**Application No:** FP/137/20/DOC

**Site Address:** Land On West Side Of Stanhorn Grove Felpham PO22 8FS

**Description of Works:** Approval of details reserved by condition imposed under ref FP/171/18/PL relating to Condition Nos 21 - waste/recycling storage and 22 - external lighting.

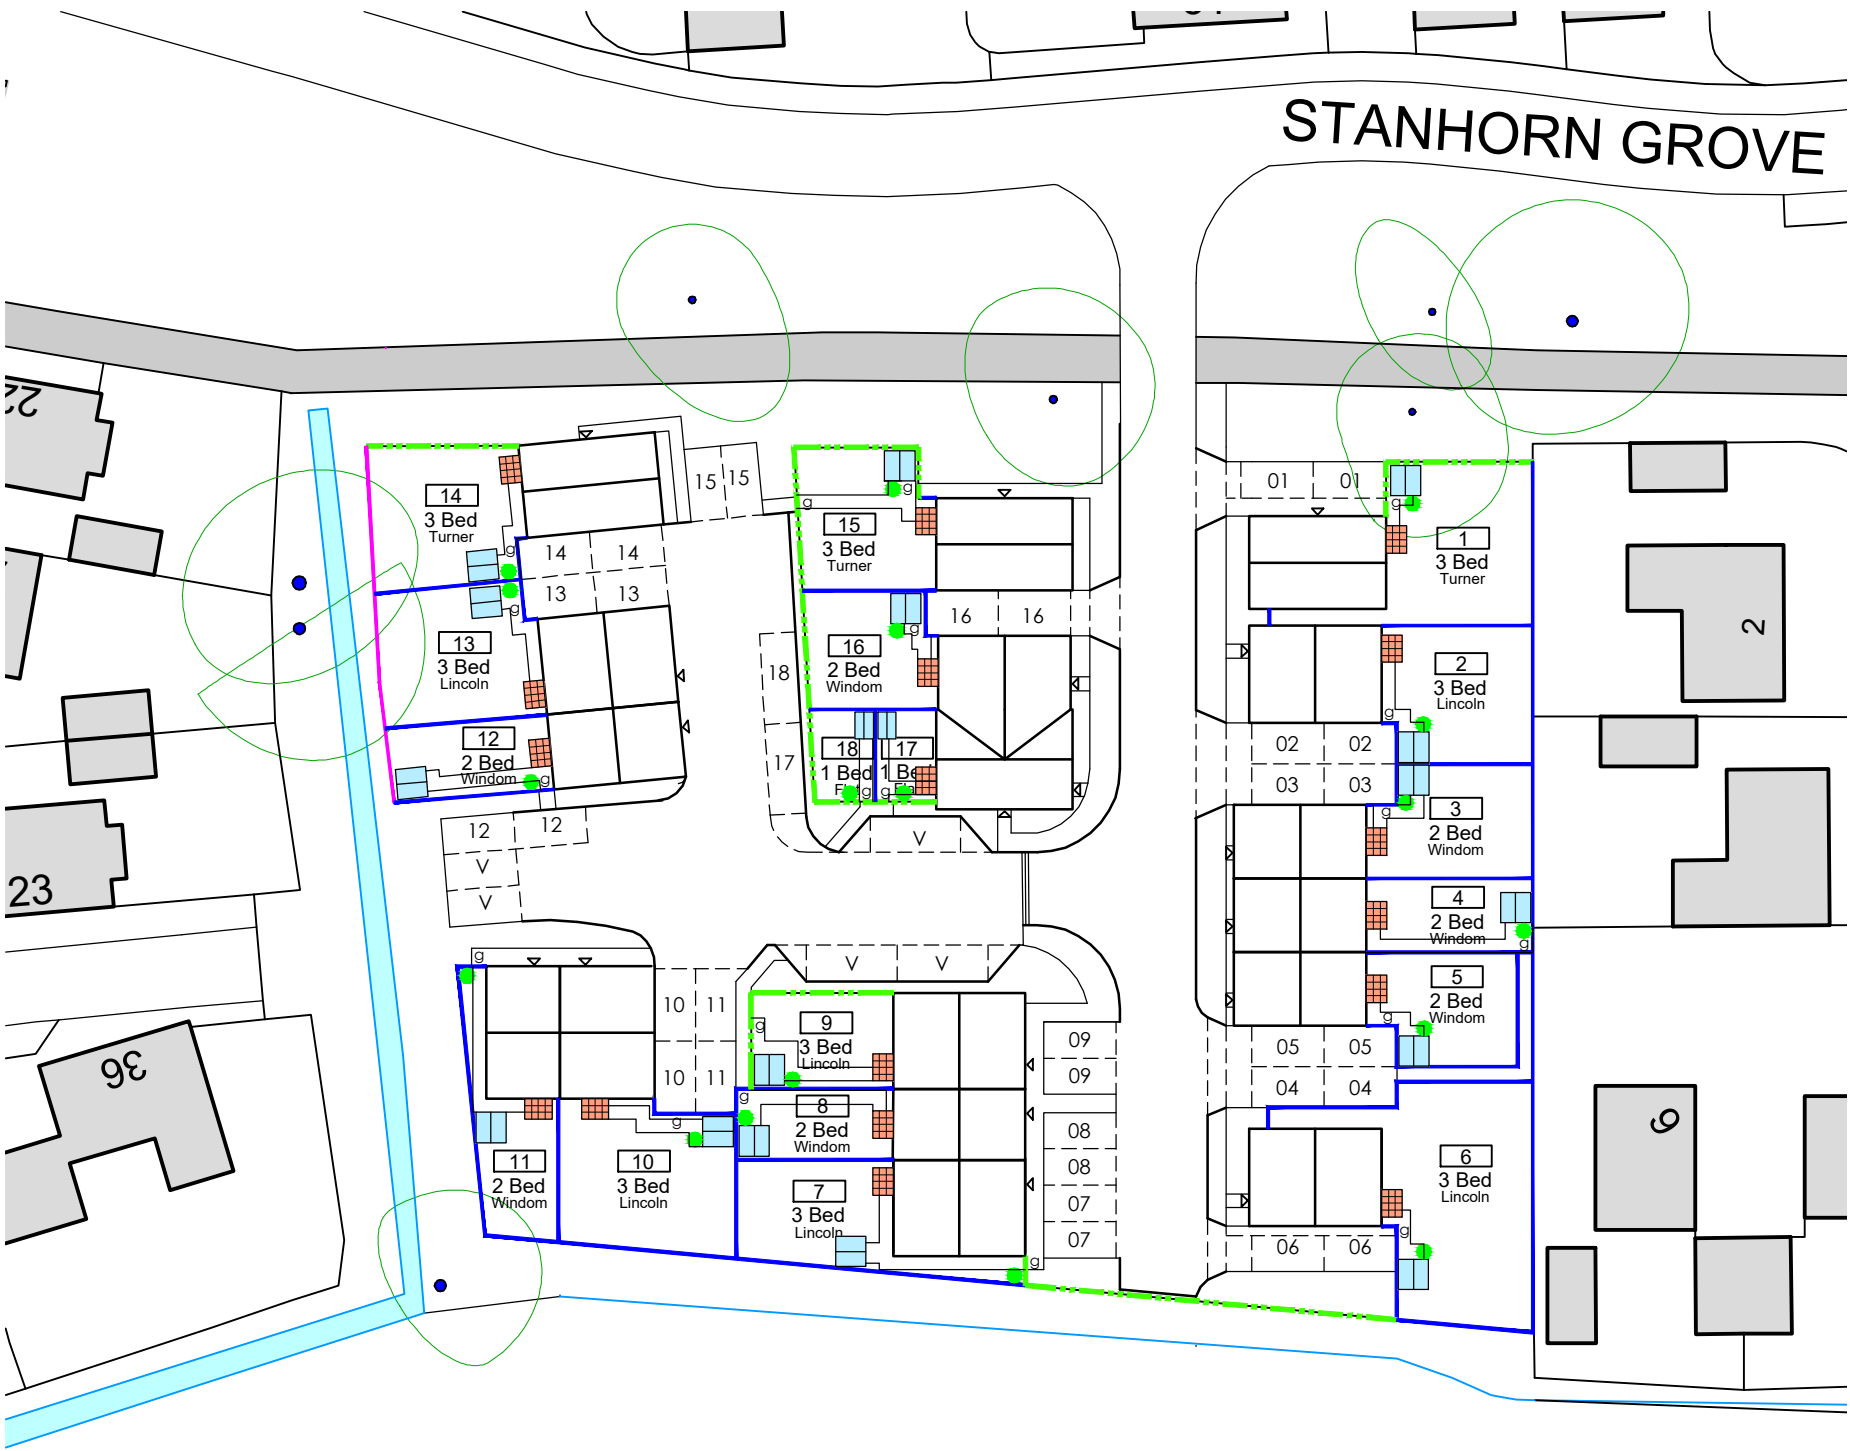
Please can further information please be submitted relating to the lighting onsite including the type of lighting units which will be used both in the communal areas but also on each unit.
